**Your Ref:** OWPC23329  
**Our Ref:** FG/46/19/PL  
**Please ask for:**  
Mr Z Denton

3rd June 2019

Refurbishment of existing car park. Providing a permeable SuDS ground reinforcement grid paving system. Providing a level allocated car parking spaces.  
East Of The Bluebird Cafe South Drive Ferring

01 PROPOSED SITE PLAN
Scale: 1:200

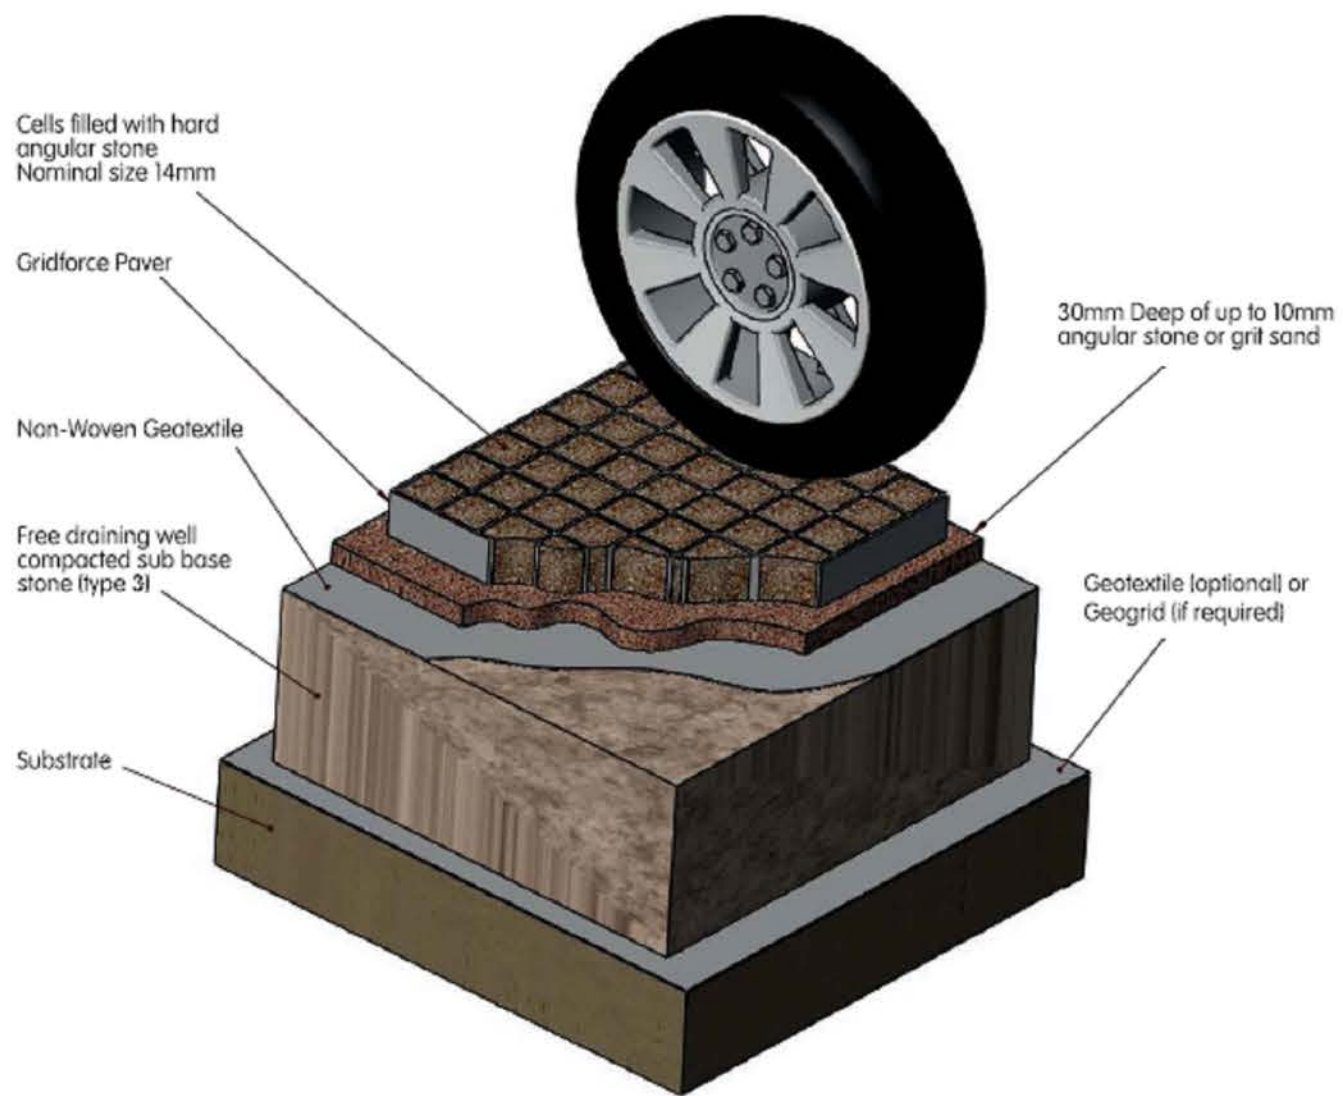
*Ferring Parish Council would like to draw the attention of Officers to the footpath as defined on the WSCC PRow map which is not detailed on the applicant's location or site plans. The footpath forms the northern boundary of the site along the southern boundary of the properties in The Strand. This right of way provides the access to the public toilets from the beach as well as linking the other main access footpaths to the site and rear access to the adjacent properties. Any marked parking bays must ensure that the footpath is clearly defined and not obstructed, to ensure safe and unimpeded pedestrian thoroughfare at all times and suitable for wheelchair / disabled use. A physical delineation barrier should be made conditional to reduce safety risks.*
